WEST SUSSEX COUNTY COUNCIL CONSULTATION

TO:	Arun District Council FAO: Ms M Tomalova
FROM:	WSCC - Highways Authority
DATE:	9 June 2021
LOCATION:	Aronel Cottage Nursing Home 5-11 Highfield Road Bognor Regis PO22 8BQ
SUBJECT:	BR/135/21/PL Three storey side extension, additional 16 double bedrooms with en-suite, lift & additional living accommodation (resubmission following BR/234/20/PL). This site is in CIL Zone 4 (Zero Rated) as other development.
DATE OF SITE VISIT:	Site visited previously/site known to LHA Officers
RECOMMENDATION:	Advice
<u>S106</u> CONTRIBUTION TOTAL:	n/a

Drawing Title:
BLOCK PLAN

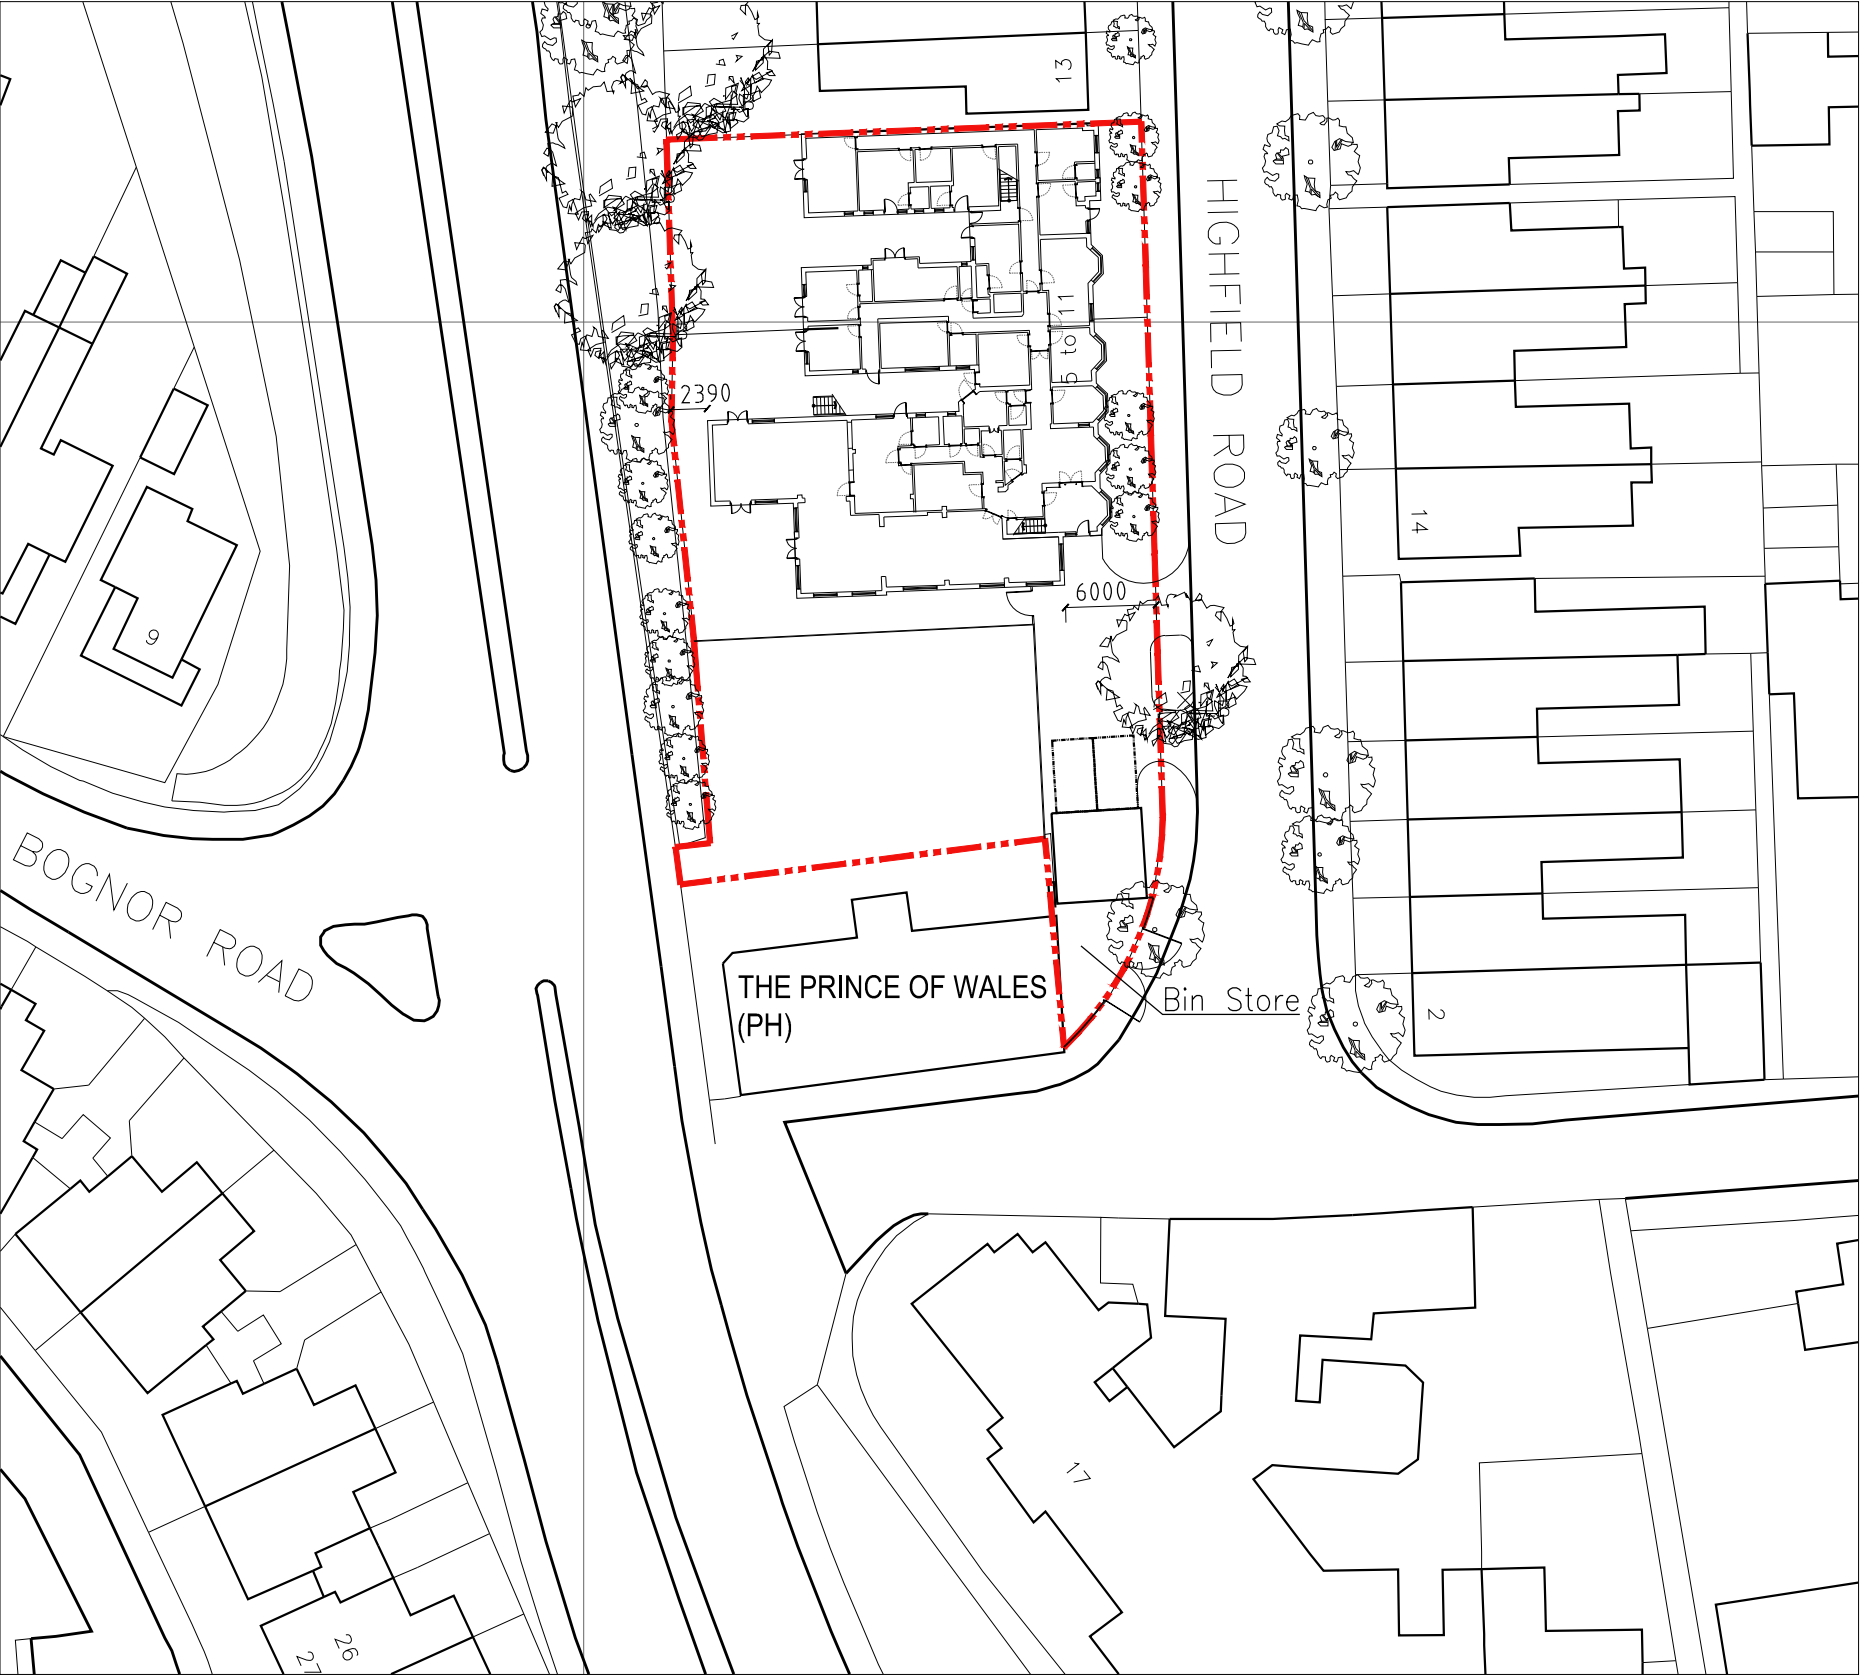
It is noted that the application has been amended and re-submitted for fewer rooms (16), but with 7 parking spaces still proposed. Again no information has been provided to allow the LHA to determine if the proposed 7 spaces will fully cater for the site to prevent over spill parking onto the surrounding roads; however it is noted that the layout of the parking spaces has been improved compared to the previous application. Local junctions of the highway are also protected to prevent parking in unsafe locations so from a highway safety point of view there would be no concerns raised IF over spill parking occurred, but the Local Planning Authority may wish to consider over spill parking from an amenity perspective.

Vehicle parking and turning - No part of the development shall be first occupied until the vehicle parking and turning spaces have been constructed in accordance with the approved plan. These spaces shall thereafter be retained for their designated use.
